An  
Bord  
Pleanála

**Board Direction**  
**BD-011810-23**  
**ABP-313302-22**

The submissions on this file and the Inspector's report were considered at a Board meeting held on 20/02/2023.

APARTMENT BLOCK A  
FIRST FLOOR PLAN

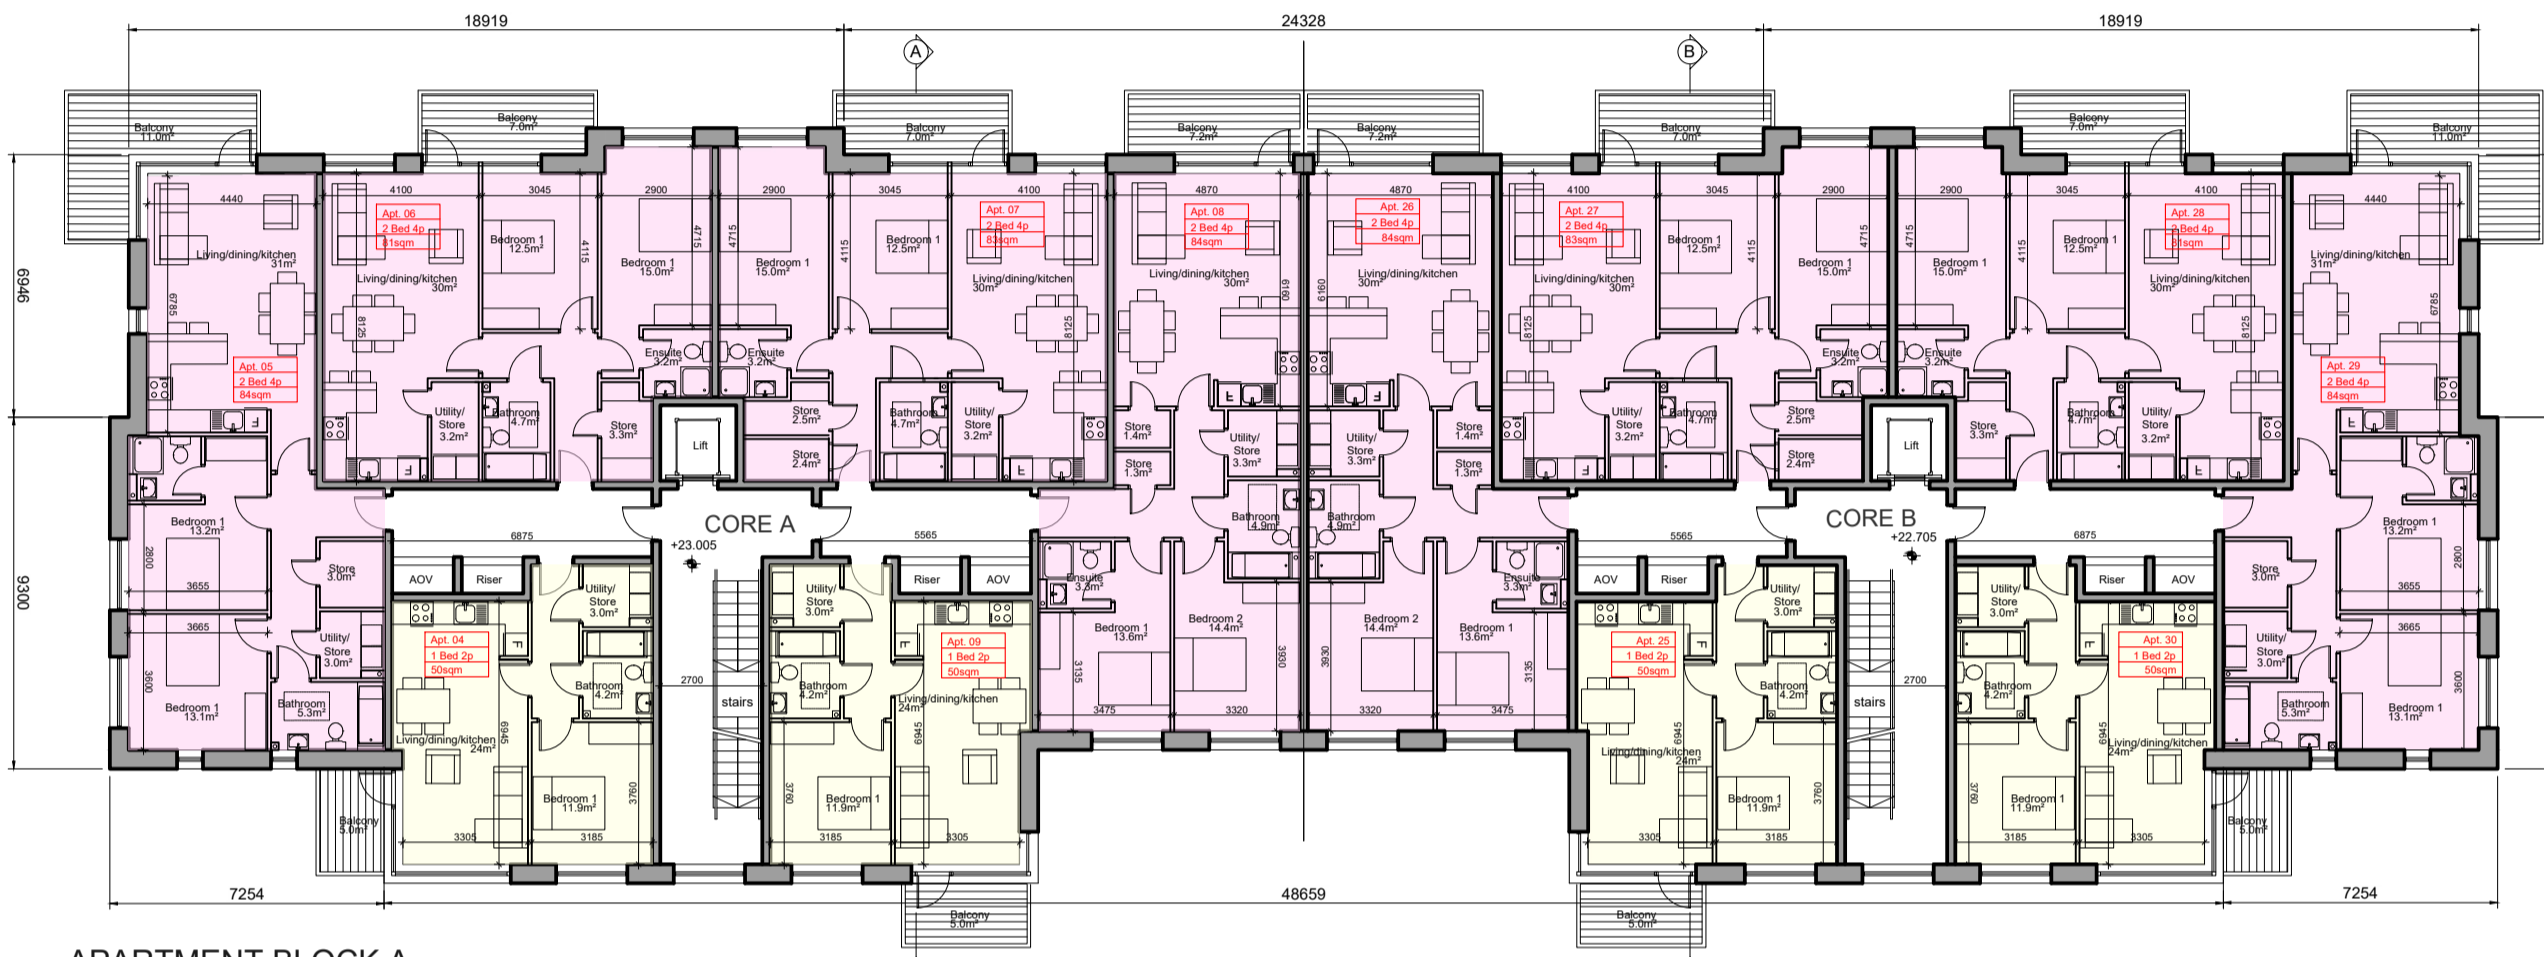
- (c) Apartment Numbers 01, 02, 03, 22, 23 and 24 in Apartment Block A; Apartments 01 and 02 in Apartment Block B1; Apartments 01 and 02 in Apartment Block B2; and Apartments 01, 02 and 03 in Apartment Block C shall be provided with own door access.

Revised plans and particulars showing compliance with these requirements shall be submitted to, and agreed in writing with, the planning authority prior to commencement of development.

APARTMENT BLOCK B1
EAST ELEVATION (STREET ELEVATION)

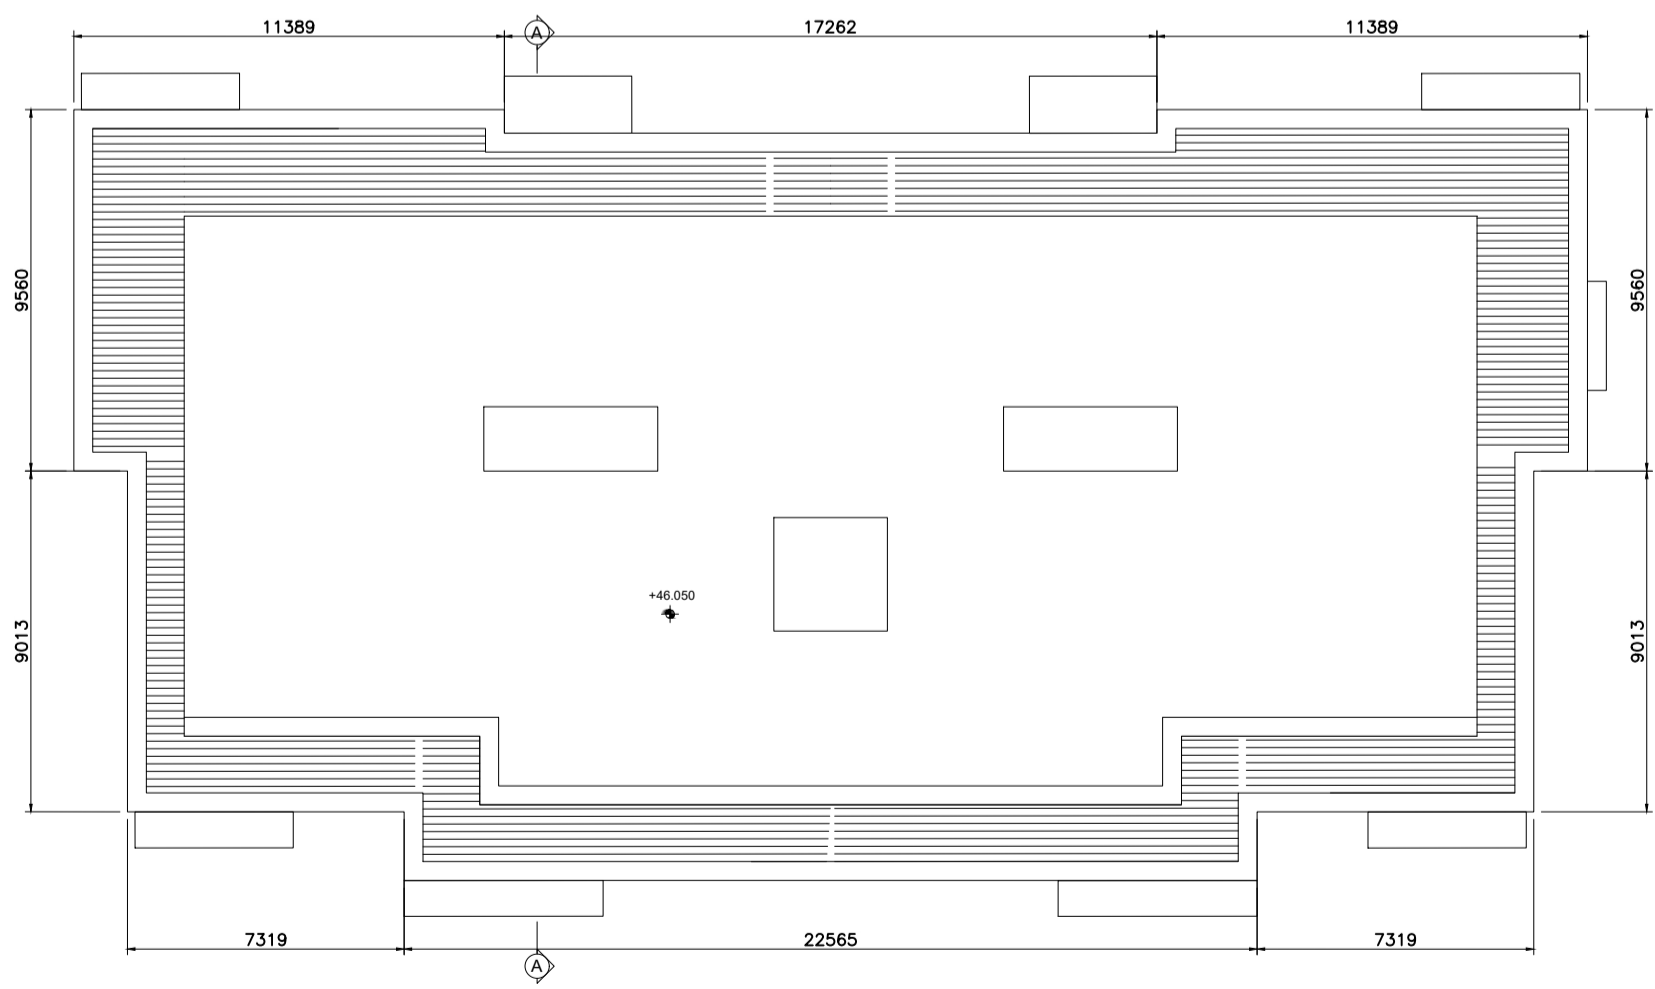
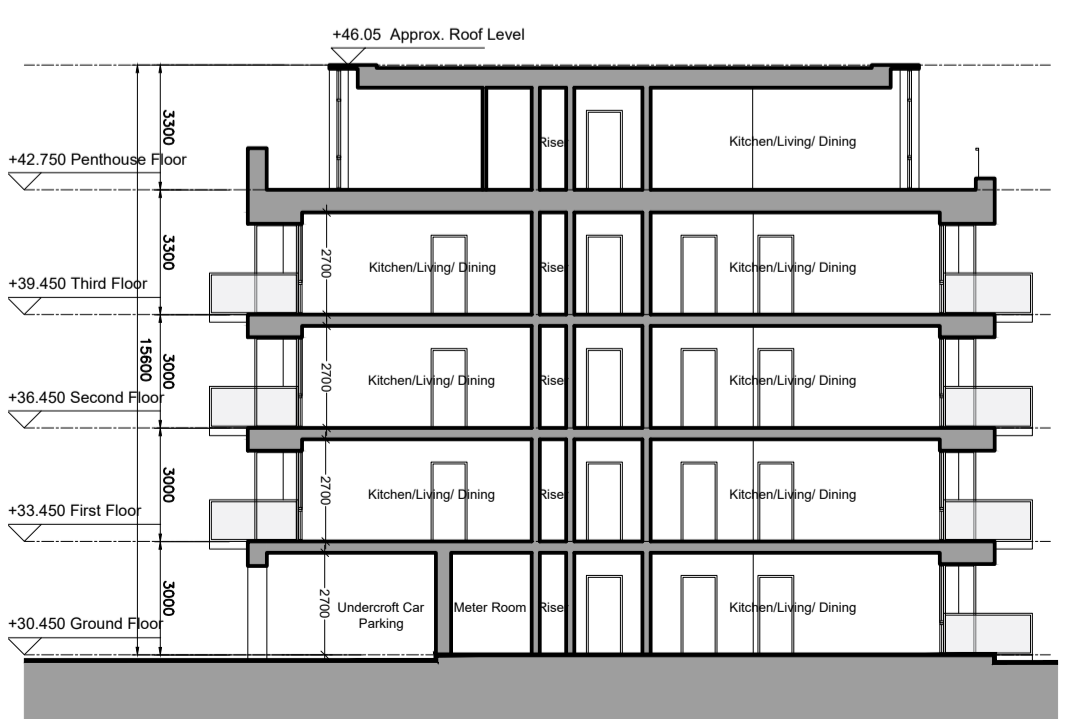
7. The proposed render finish from Apartment Blocks A, B1, B2 and C and the cladding at the top floor level of Apartment Blocks B1, B2 and C shall be permanently omitted and replaced with a suitably high quality material. A schedule of all materials to be used in the external treatment of the development to include a variety of high-quality finishes, such as brick and stone, roofing materials, windows and doors shall be submitted to and agreed in writing with, the planning authority prior to commencement of development. In default of agreement the matter(s) in dispute shall be referred to An Bord Pleanála for determination.

APARTMENT BLOCK B2
NORTH ELEVATION

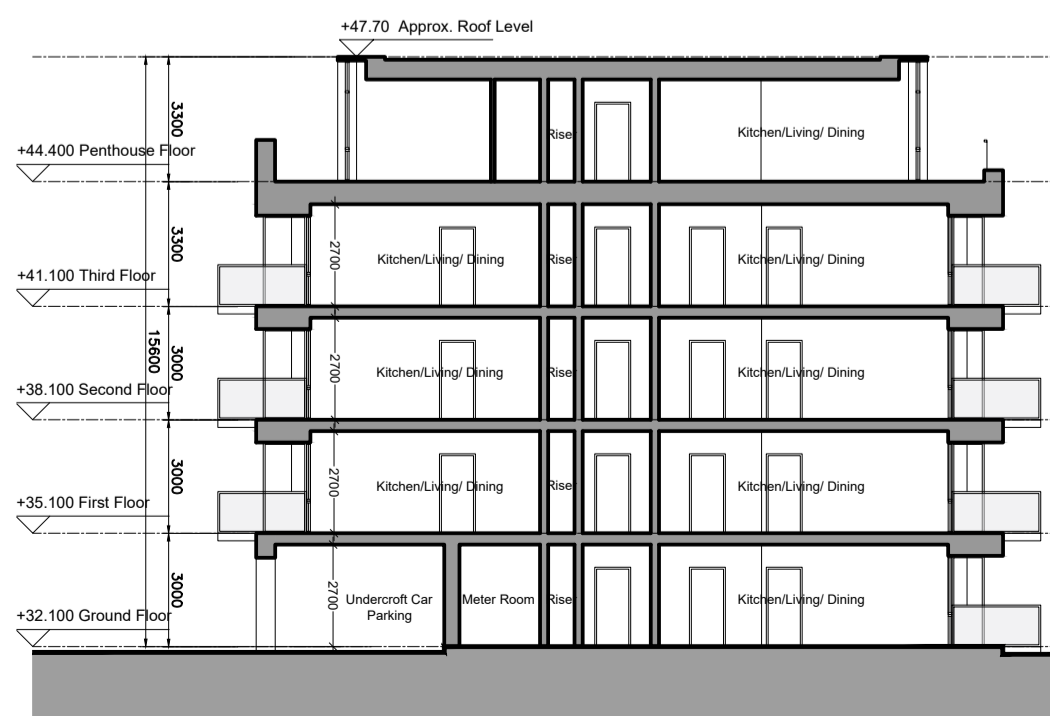
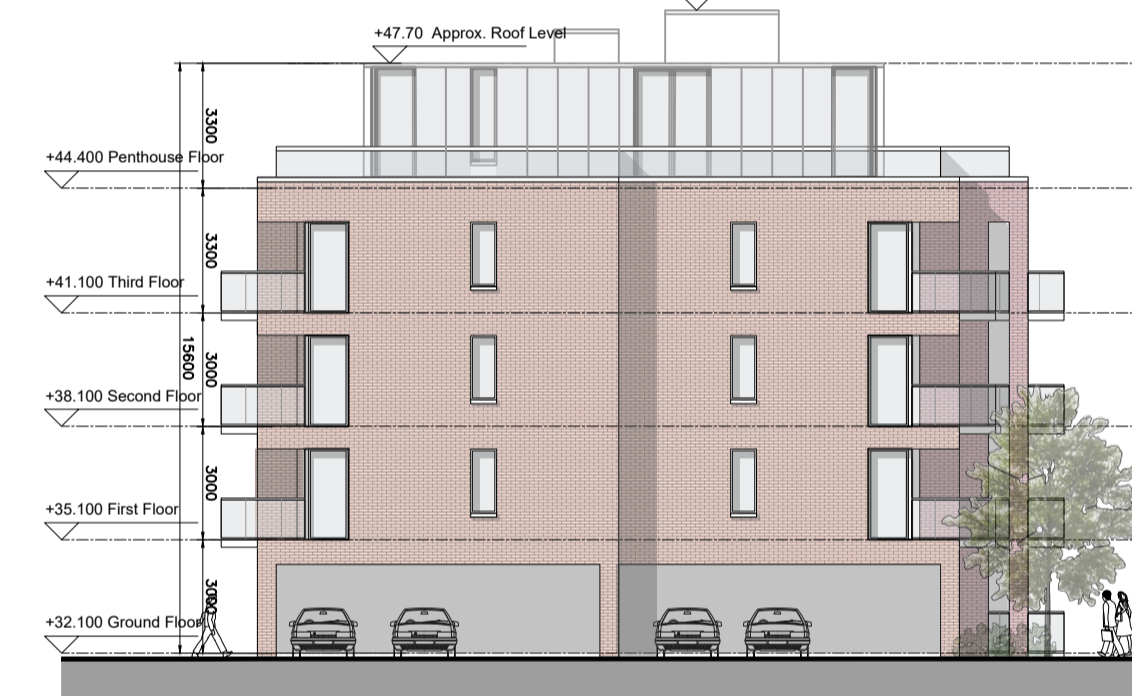
- (e) The windows on the northern elevation of Apartment Numbers 08, 09, 16, 17, 24, 25, 30 and 31 in Apartment Block B2 shall be permanently fitted with louvres or obscure glazing.

- (f) The windows on the southern elevation of Apartment Numbers 04, 05, 12, 13, 20, 21, 28 and 29 in Apartment Block B2 shall be permanently fitted with louvres or obscure glazing.
